CYNGOR SIR
YNYS MÔN
ISLE OF ANGLESEY
COUNTY COUNCIL

Review of Horizon's DCO Submission (Off Site Power Station Facilities)

Dyddiad / Date: 27/09/2018

Figure 1-1 Off-site Power Station Facilities site boundary

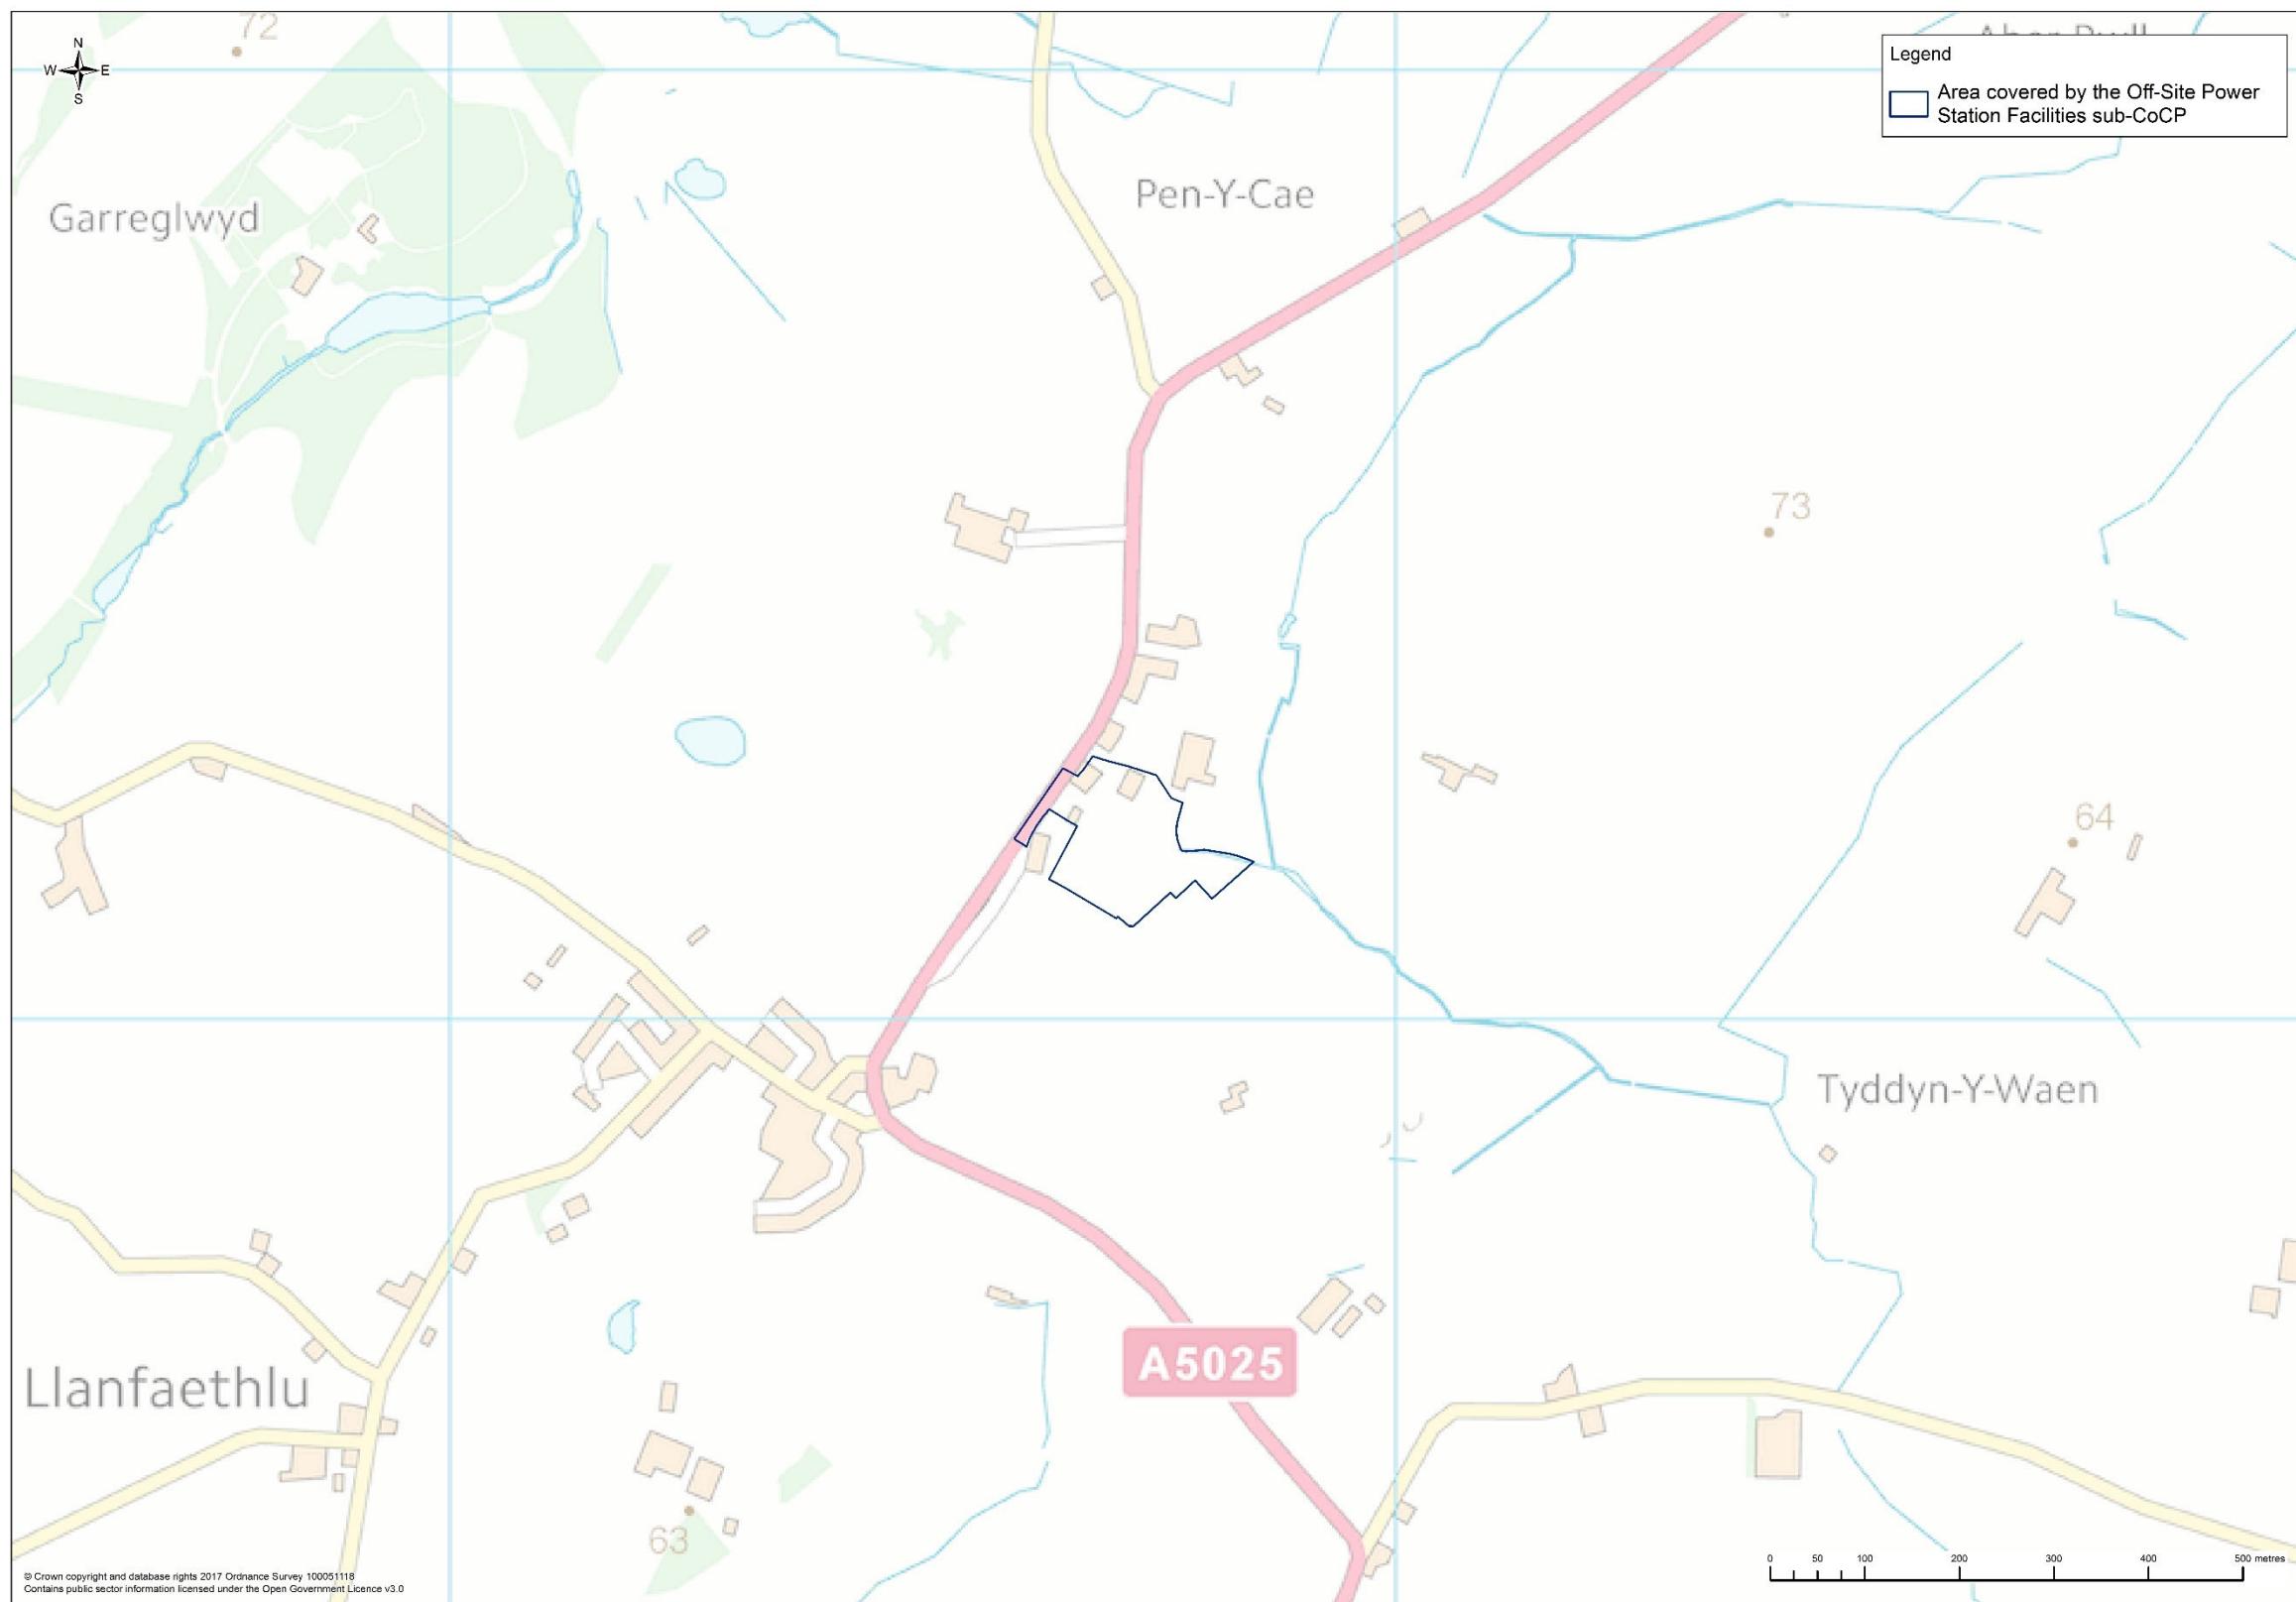
- 4.4.3 The Council would wish to see additional screen planting to be placed along the western and northern boundaries of the site whilst it would wish to agree final details including samples of the roofing and walling materials proposed for the buildings with consideration given to ways in which the appearance of the MEEG/AECC could be broken up visually.

- ii. Consideration should be given how the appearance of the MEEG/AECC could be mitigated given that it dominates the site when viewed from the AONB.
- iii. A revised outline landscape scheme should be submitted that includes: retaining more of the existing mature vegetation on and around the boundaries of the site; continuing the low stone wall along the northern and western boundaries and using planting to soften the site boundary alongside the A5025; a new native hedgerow with hedgerow trees along the northern boundary of the site; planting outside the security fence to be undertaken in advance of the commencement of construction to enable the planting to start establishing and to begin to soften the boundary fence once this is installed; a schedule of typical plant species mixes for the hedgerow, shrub and tree planting and grassland areas, together with approximate plant numbers and an outline of the soil preparation, planting, seeding and maintenance operations to be undertaken; the species mixes and an outline of the soiling, seeding and maintenance operations to be undertaken in the overspill parking area.

**Figure 12-1 Previously undisturbed areas of the Off-site Site Power Station Facilities site**

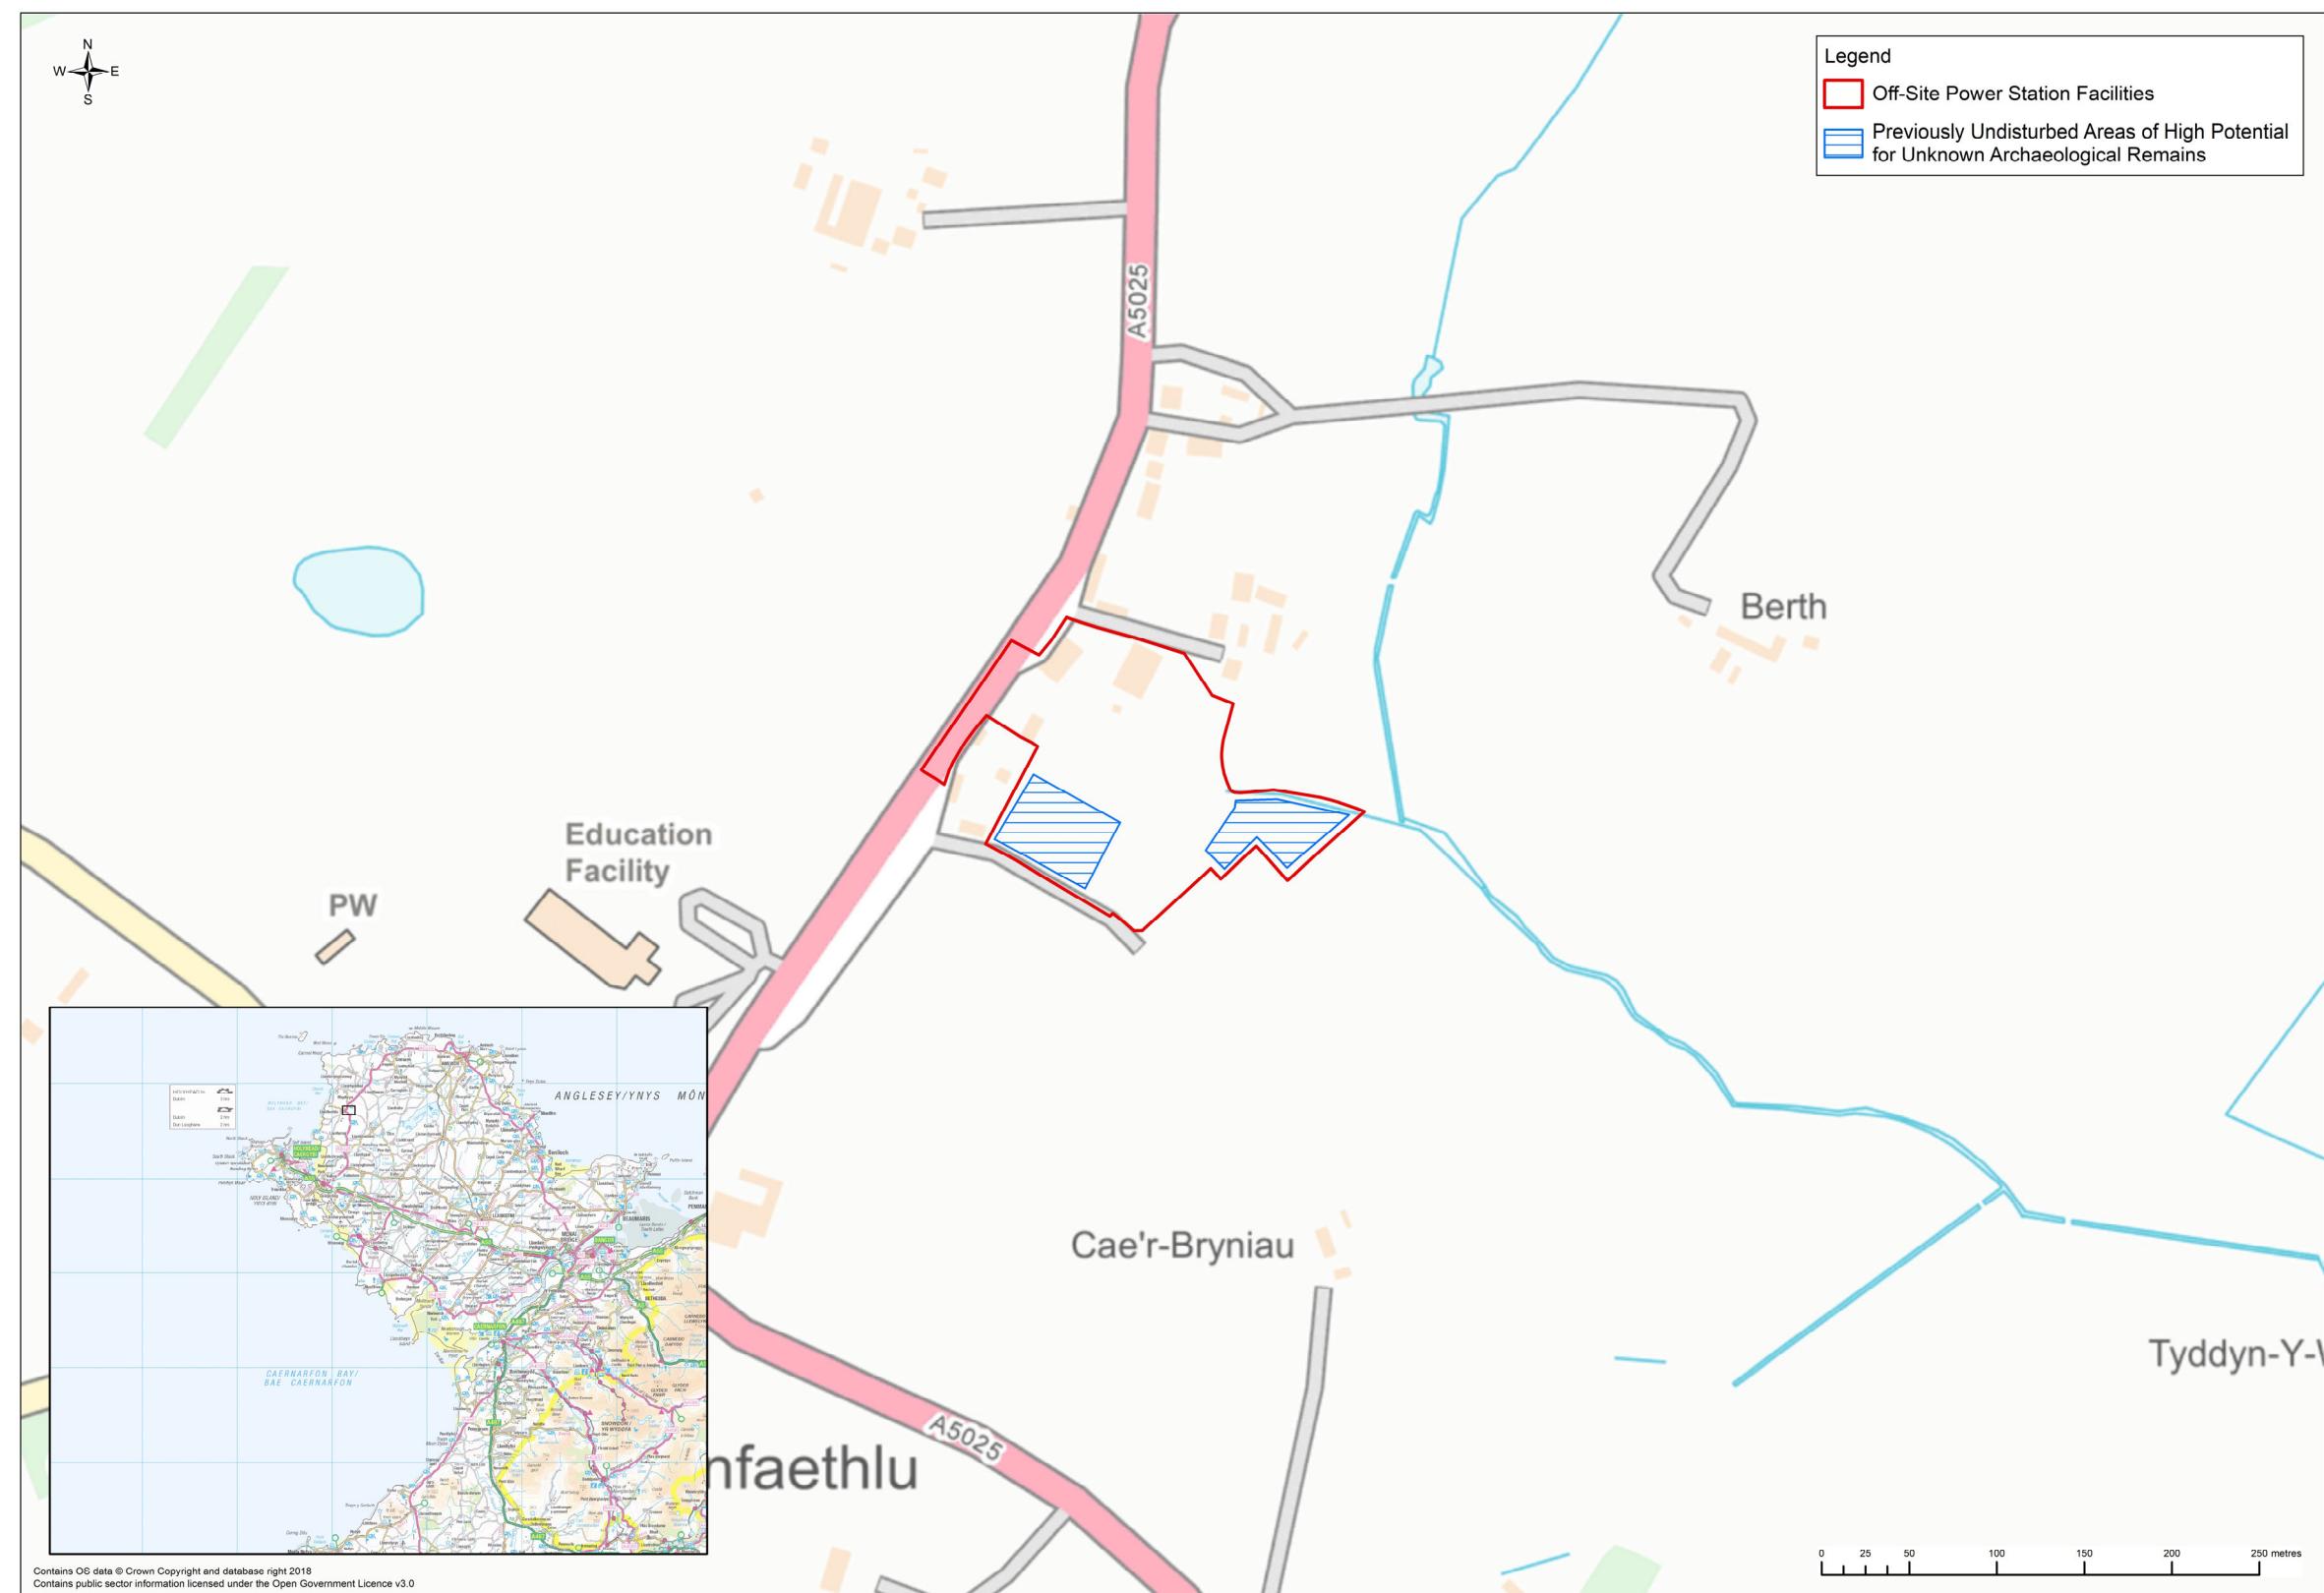
- 4.1.1 IACC has reviewed the submitted assessment of effects upon the historic environment contained within ES Volume E. Whilst it has some concerns over the specific valuations of archaeological remains it recognises that because the site is predominantly brownfield the potential survival of archaeological remains is likely to be limited. The Council is of the opinion that potential effects could be mitigated through an agreed scheme of archaeological investigation.

- i. Mitigation of disturbance of archaeological remains could be adequately achieved by the implementation of an agreed scheme of archaeological investigation which should be the subject of a specific requirement rather than reliant upon reference within the sub-CoCP.
